Correction Response Narrative

Montpellier Addition

9.28.23

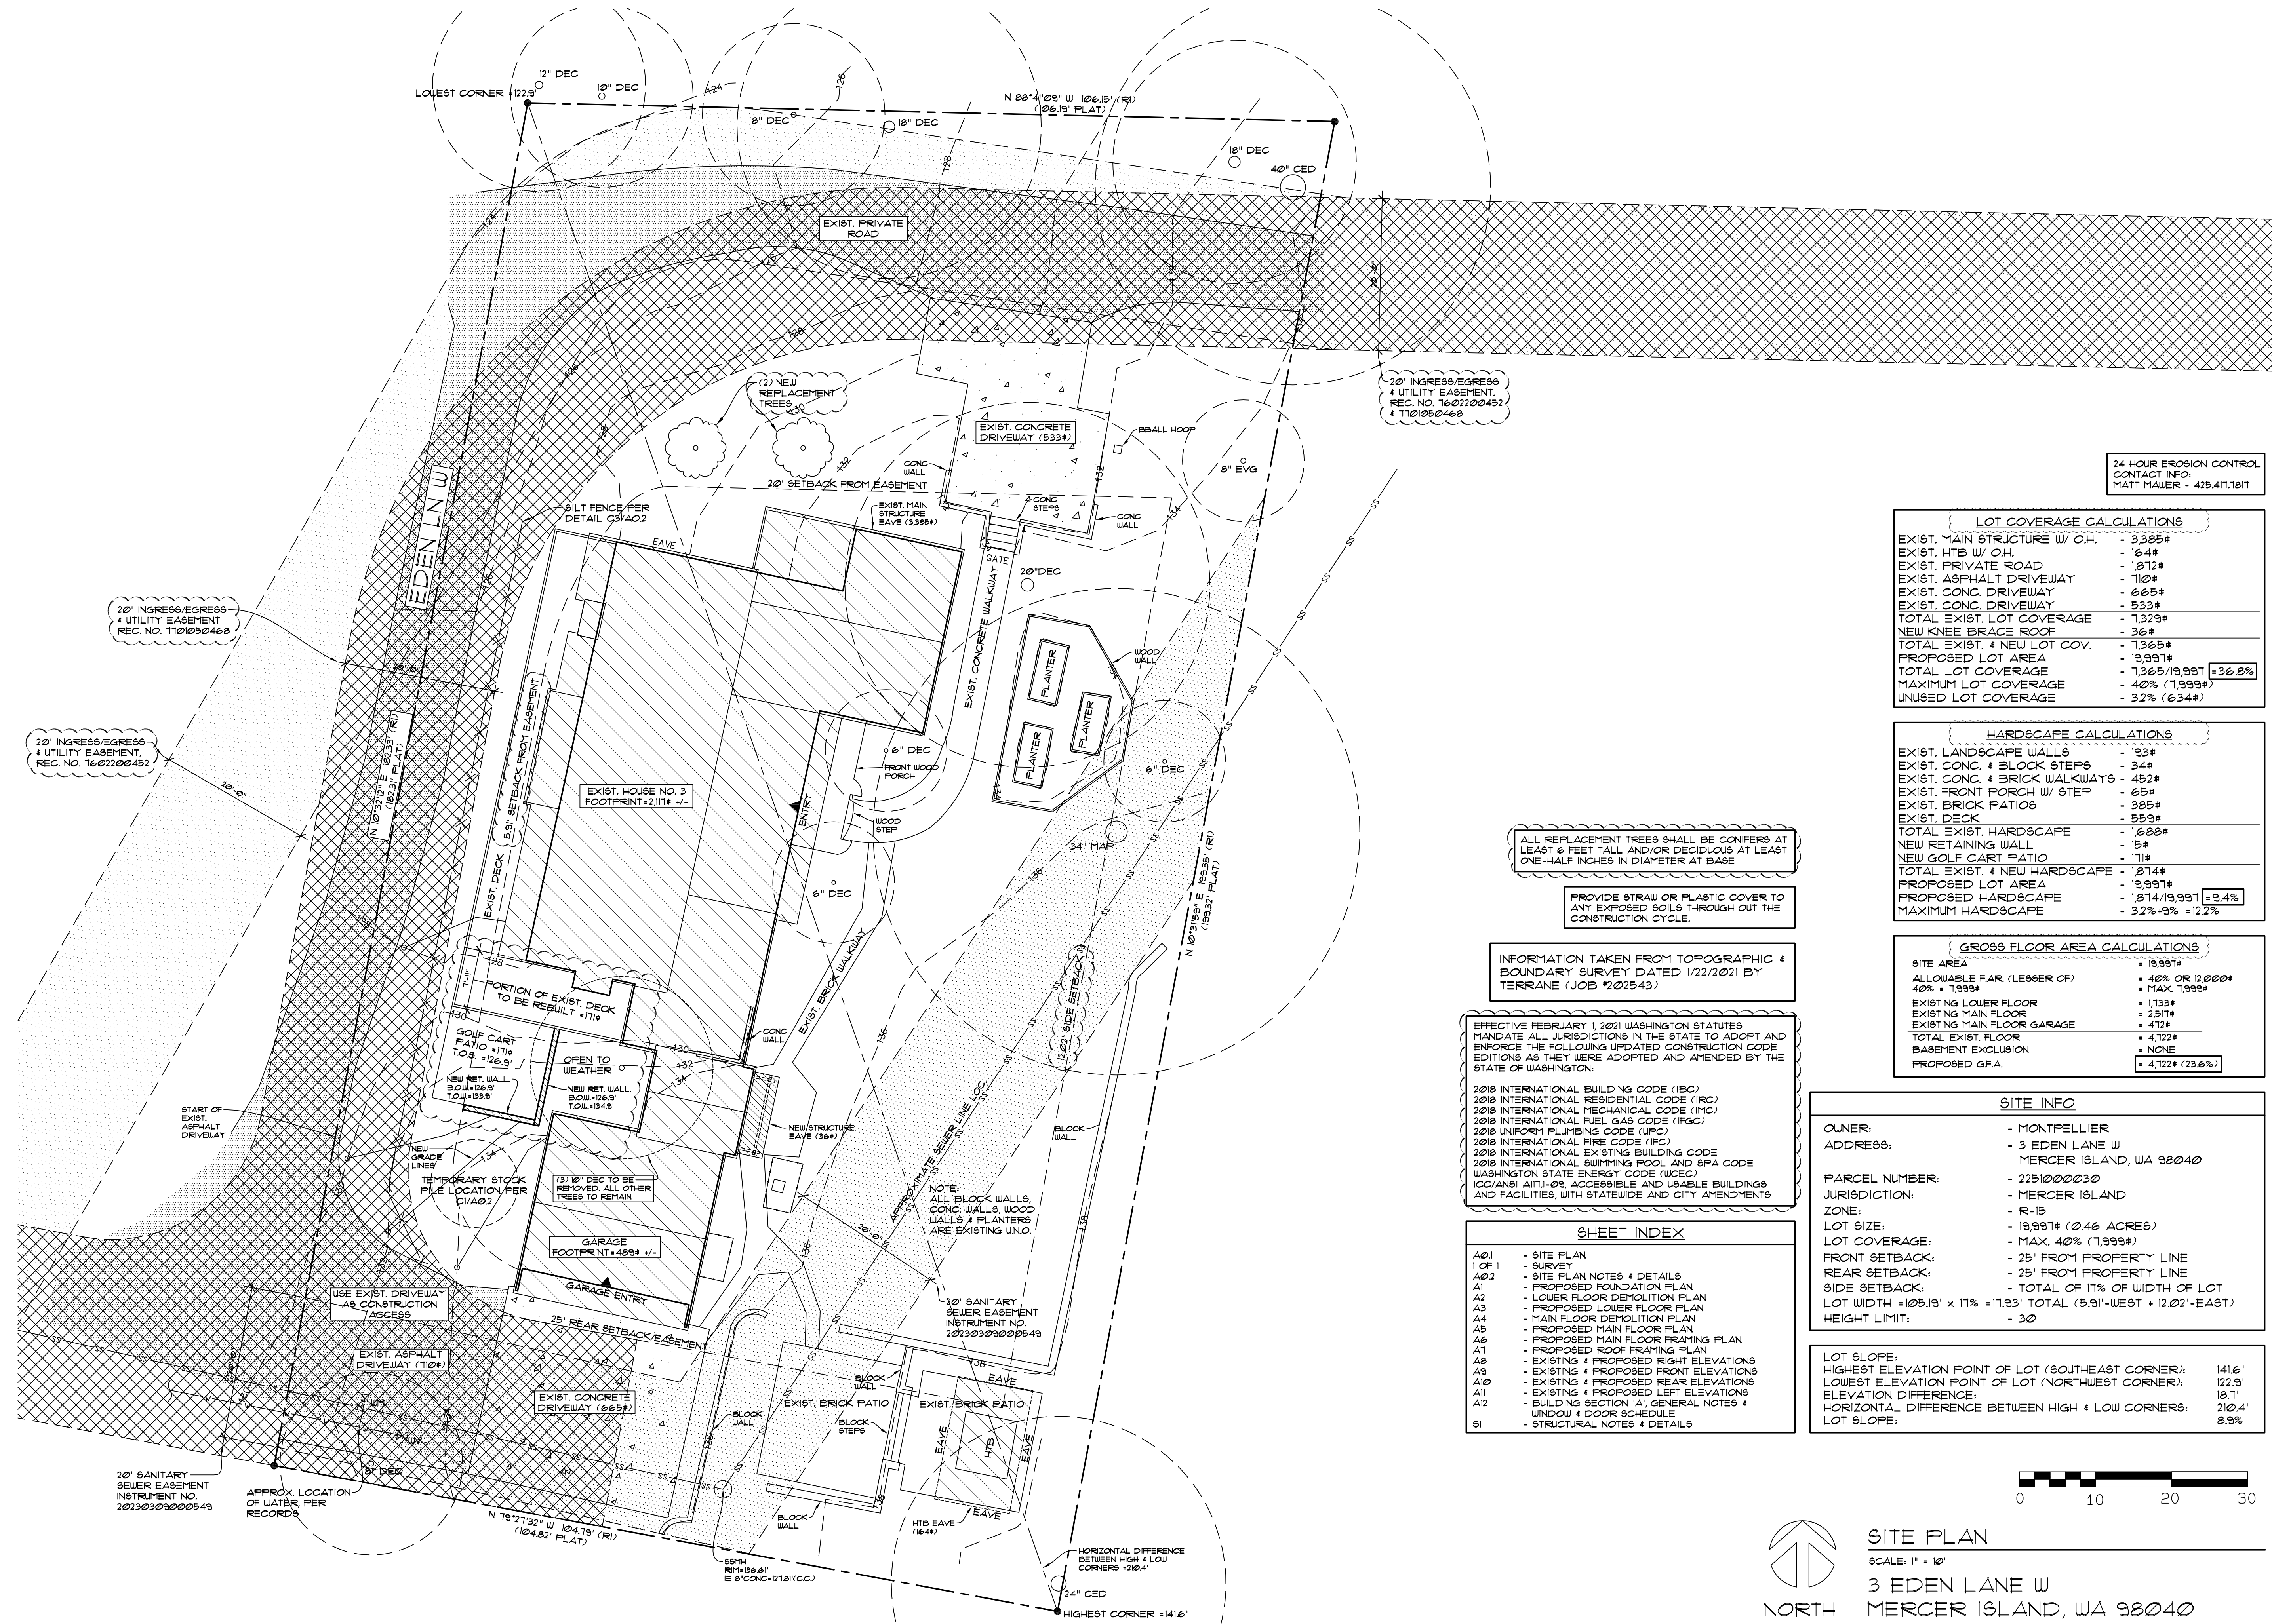
Lot Coverage / Hardscape

Scope reduction greatly lowered the lot coverage/hardscape totals from prior submittal. See updated calcs on site plan and revised site development sheet.
